Ribble Valley Borough Council
By email

Your ref: 3/2022/1039
Our ref: DC/22/3994
Date: 07-DEC-22

Location: Land adjacent to 115 Kemple View Clitheroe BB7 2QJ

Proposal: Proposed construction of two new detached dwellings with associated access and garden areas

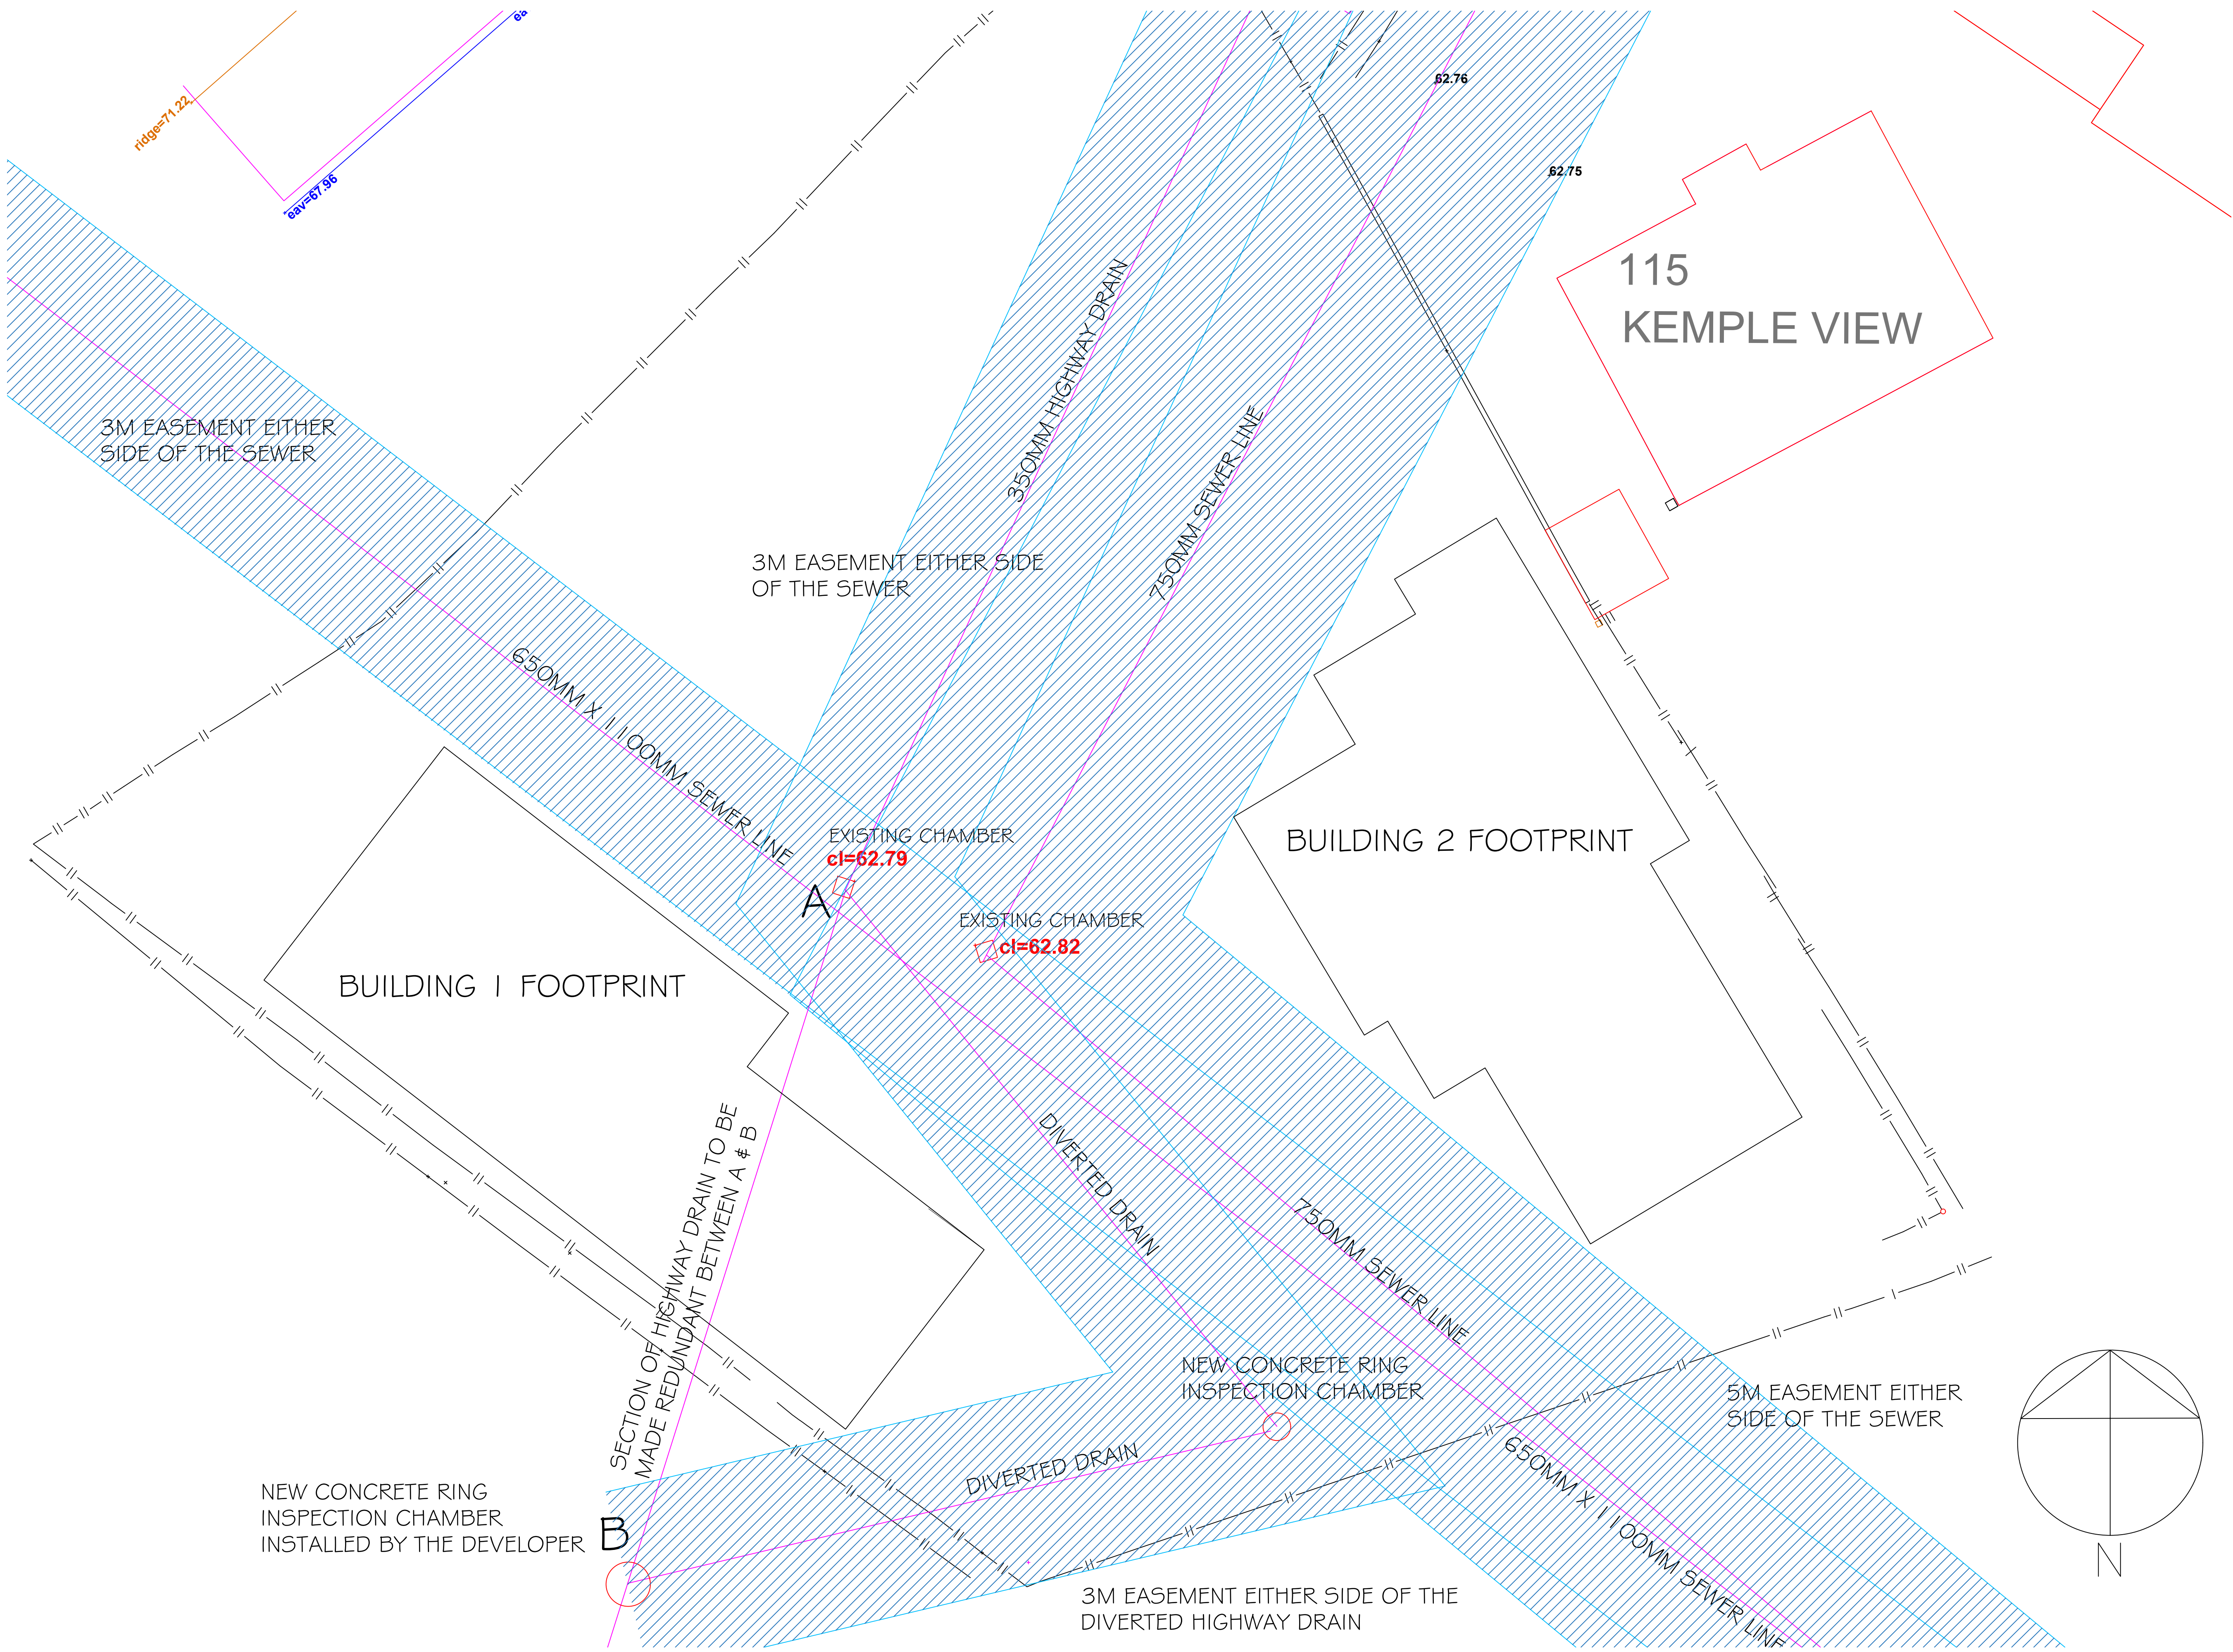
Following our review of the submitted drainage documents; Drainage Strategy Ref: PHA/366 100, Dated 12.10.2022, the plans are not acceptable to United Utilities. This is because there is insufficient information on the detail of the drainage design and we have not seen robust evidence that the drainage hierarchy has been thoroughly investigated and the proposals are not in line with the Non-Statutory Technical Standards for Sustainable Drainage Systems

We request that the applicant submits a plan outlining the proposed levels (including finished floor levels and ground levels) shown in metres above Ordnance Datum and an indicative foul and surface water drainage strategy (including cover and invert levels). It is our recommendation this information is submitted for our review so that any risk of sewer surcharge can be further assessed. The applicant should note that it may be necessary to raise finished floor and ground levels and / or include mitigation measures to manage the risk of sewer surcharge.

Following our review of the proposed site layout, we have concerns regarding the proximity of proposed development to our wastewater asset(s). To resolve this matter, and to avoid any unnecessary costs or delays to either the applicant or any future developer, we request the applicant submits a detailed site layout plan which overlays the proven location (exact line and depth) of the sewer in relation to any proposed development (including walls, fencing, parking etc.). Without this information we are unable to provide further comment and there is a risk that as the scheme progresses, the applicant, or any subsequent developer, may discover that their plans are not implementable in their existing form.

Furthermore, we request a 10m easement from the 1100 brick egg sewer in line with our easement local practice, due to the criticality of the sewer. (<https://www.unitedutilities.com/globalassets/documents/builders--developers-docs/easement-local-practice.pdf>)
